RE: REVISED DRAINAGE PLAN FOR LEW WALLACE ELEMENTARY
(J-14/D37) REVISION DATED JUNE 19, 1992

**RE: Lew Wallace Addition Grading and Drainage Plan (J14-D37)
Engineer's Stamp Dated July 1, 2002**

RE: Lew Wallace Addition Grading and Drainage Plan (J14-D37)
Engineer's Stamp Dated June 3, 2003

GRADING and DRAINAGE PLAN

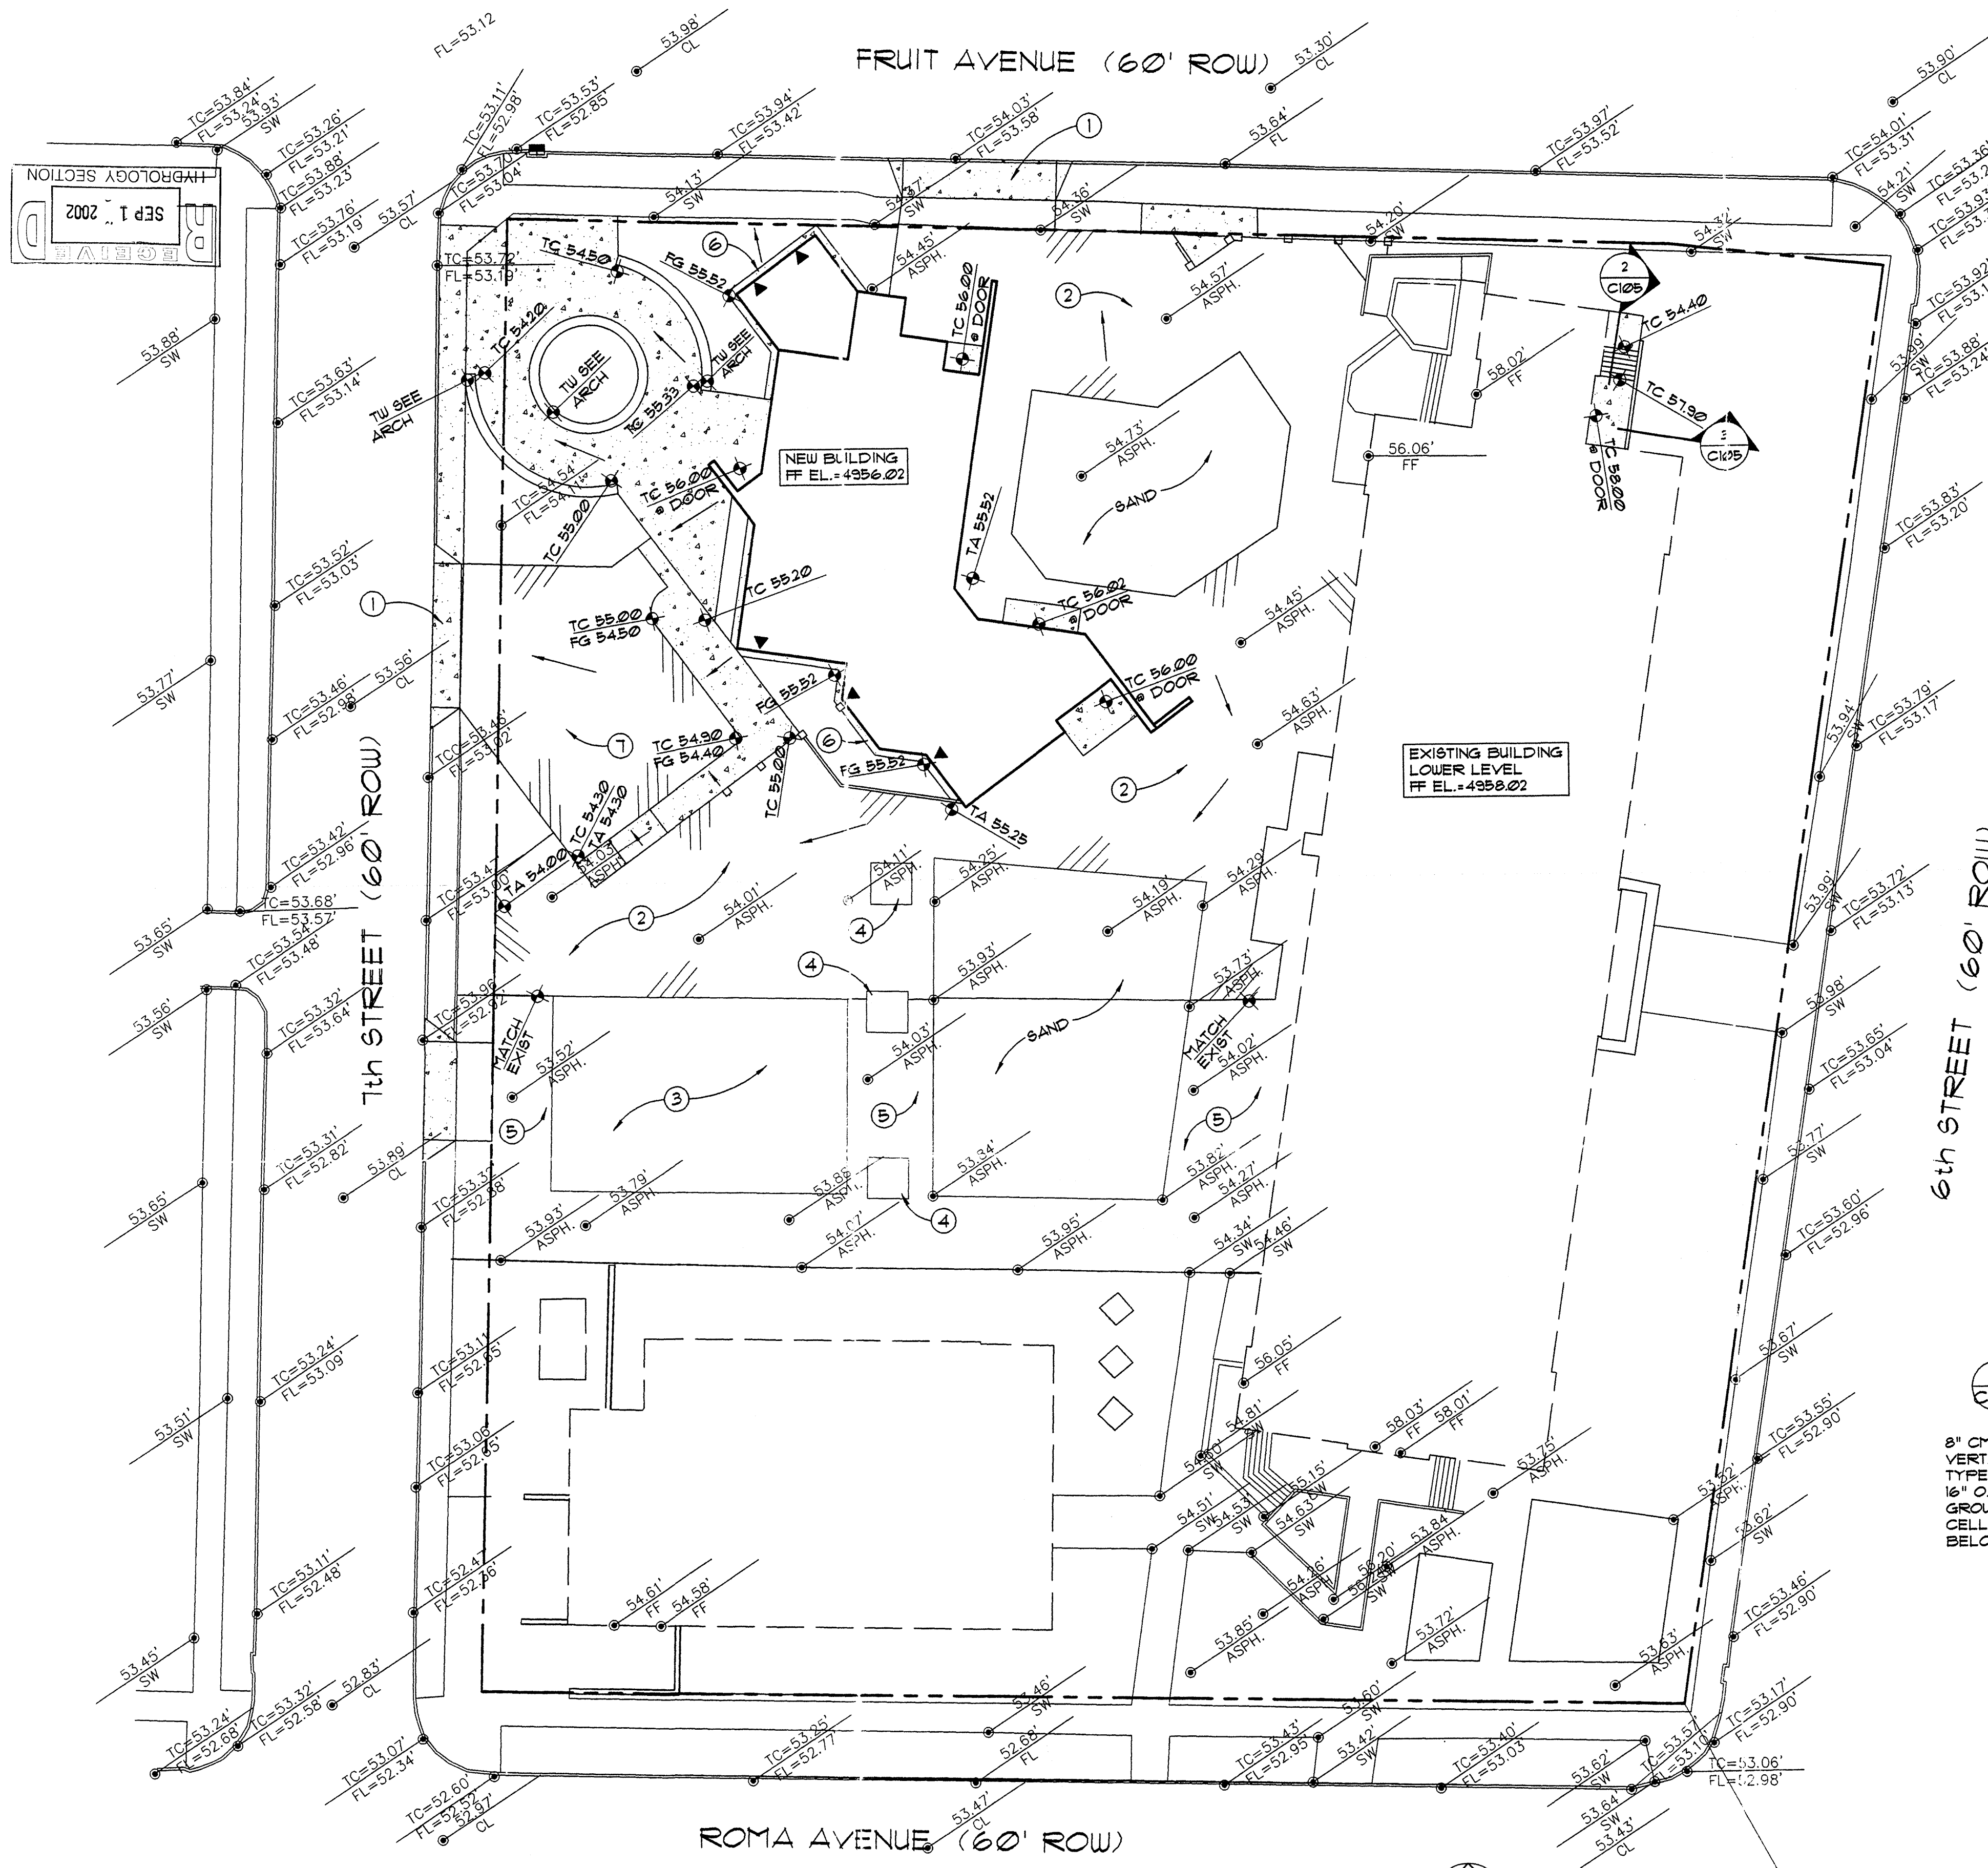
I have reviewed the above referenced grading and drainage plan received July 1, 2002 and forward the following comment regarding the northwest corner of the site: Due to the safety risk the City does not allow runoff to drain over sidewalk.

GRADING and DRAINAGE PLAN

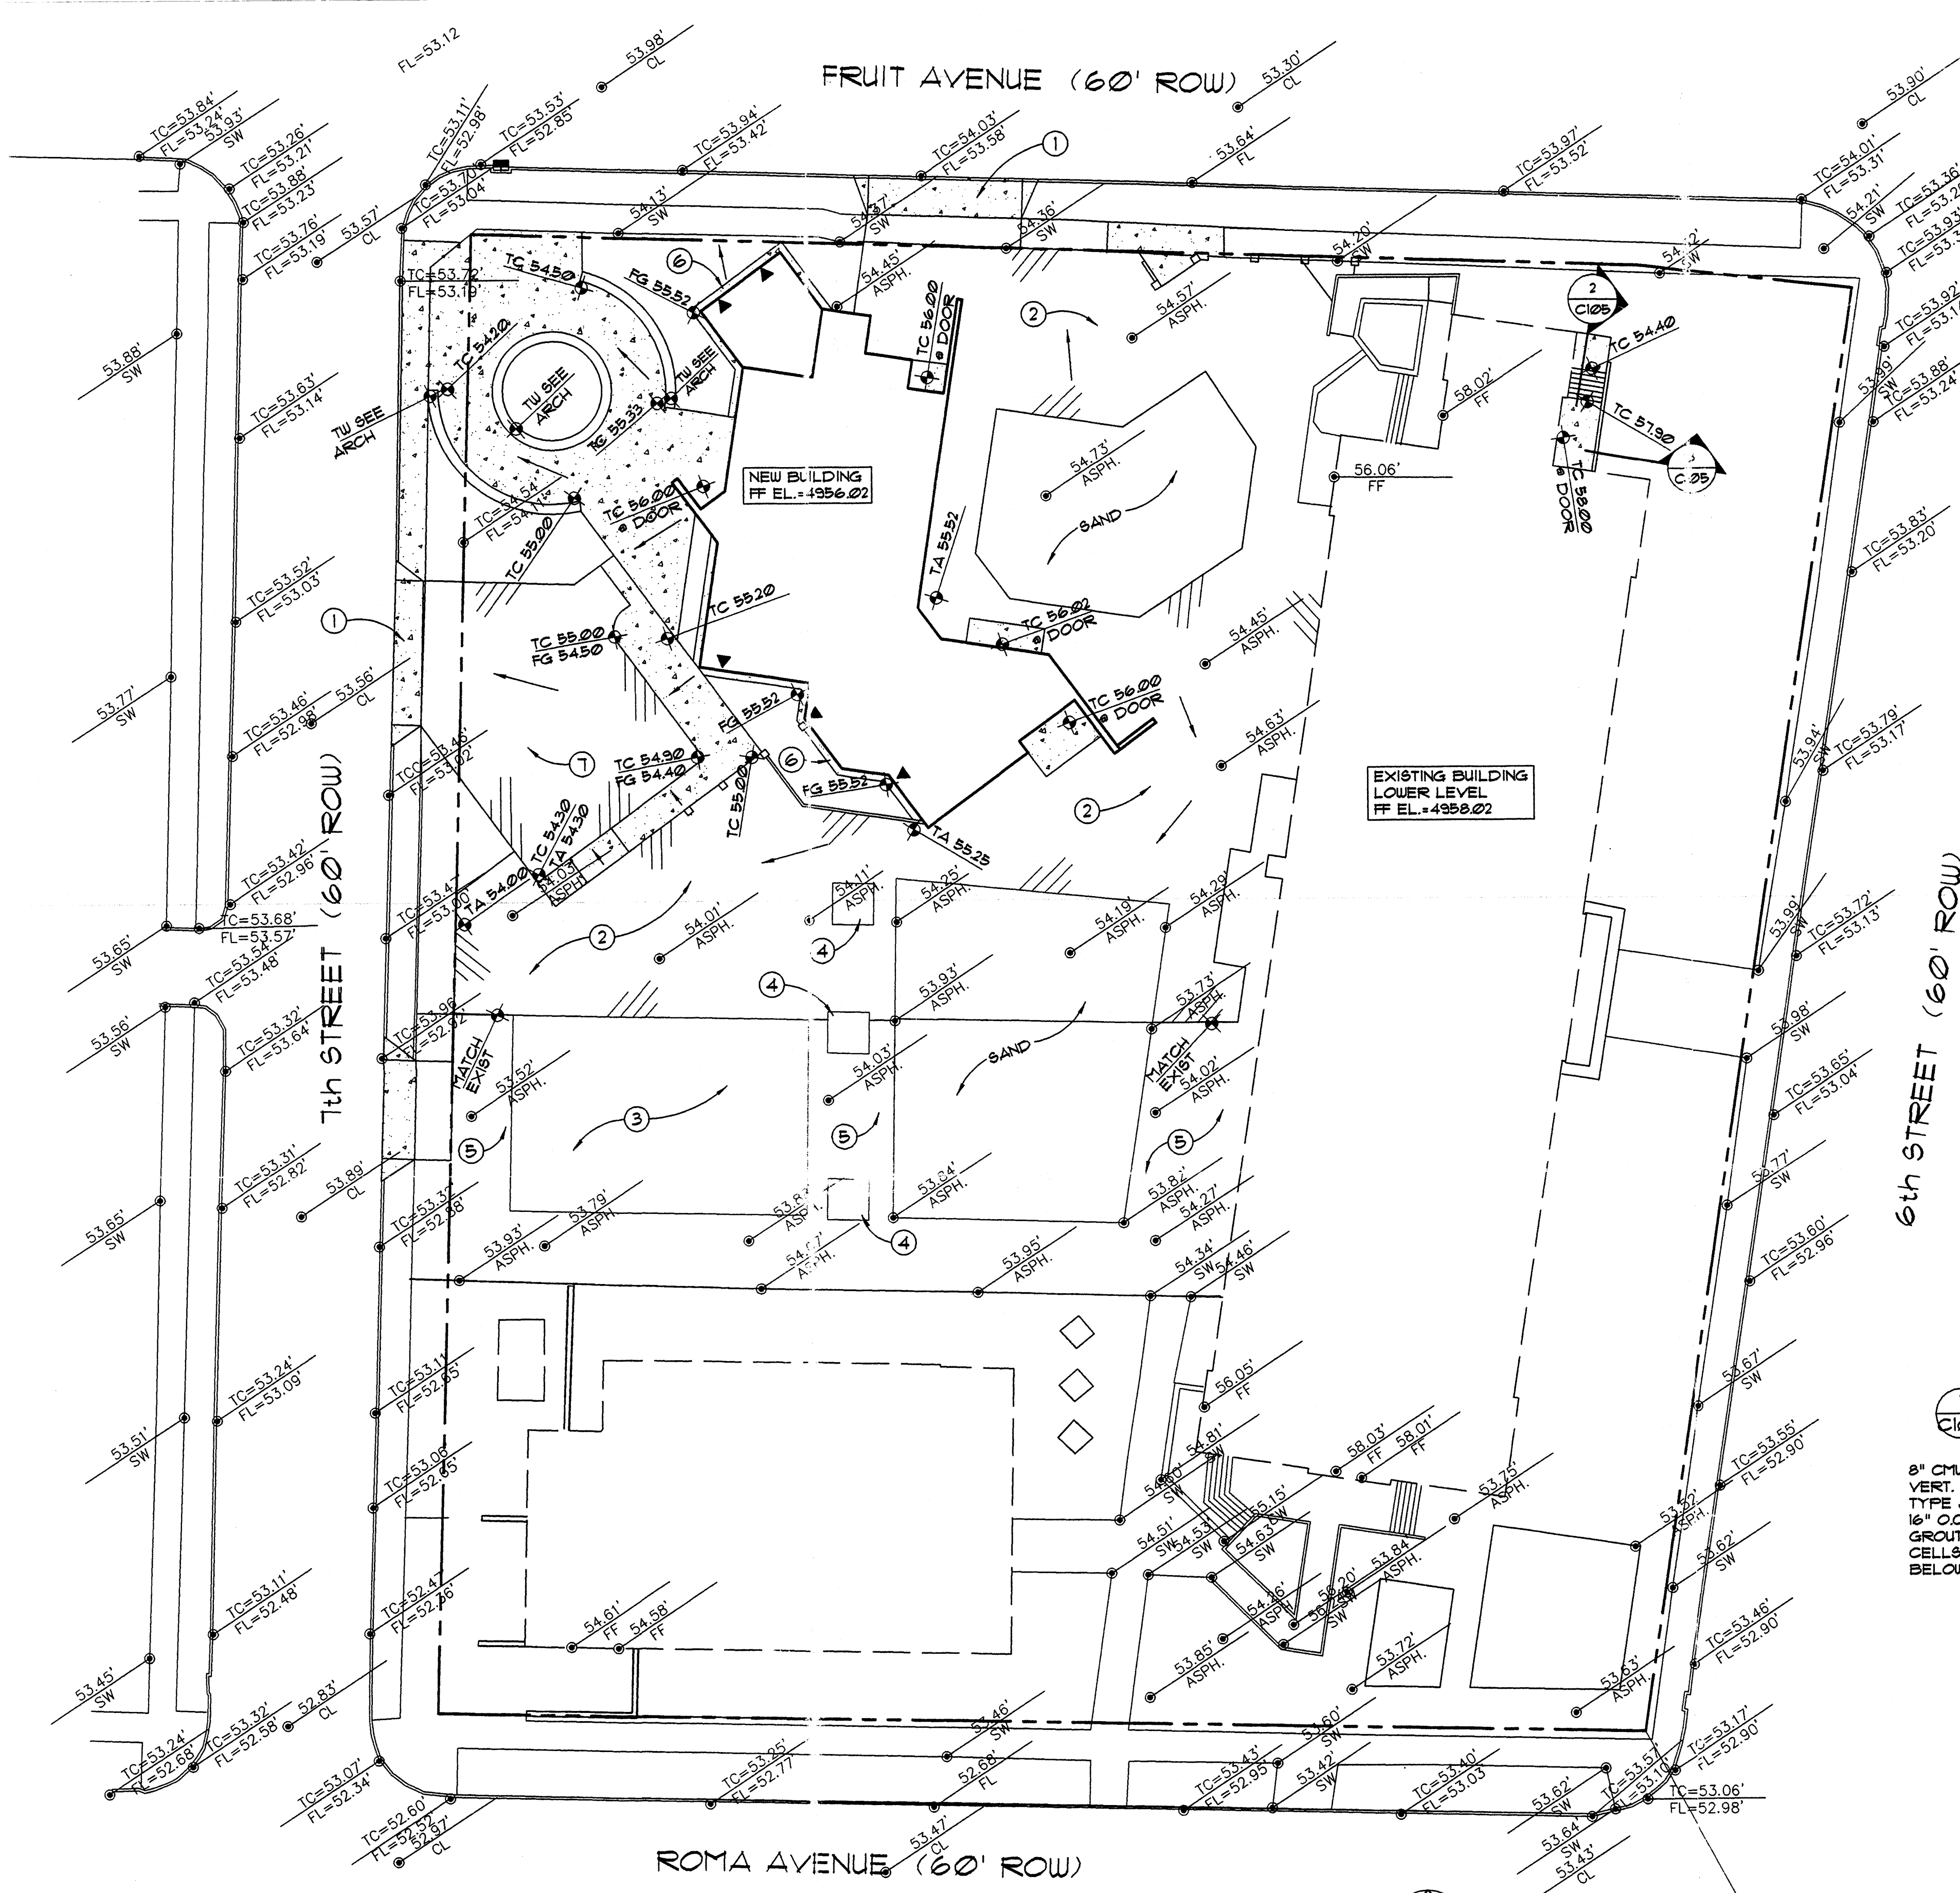
- Please show a bus bay valley gutter where the existing flow line is.
- Please provide a cross-section of the valley gutter.
- Due to safety risks the City does not allow runoff to drain over sidewalk. Please use culverts to drain runoff onto Fruit Ave. and Roma Ave. Sidewalk culverts require an SO#19, please submit two copies of plan and provide all applicable notes and signature blocks.
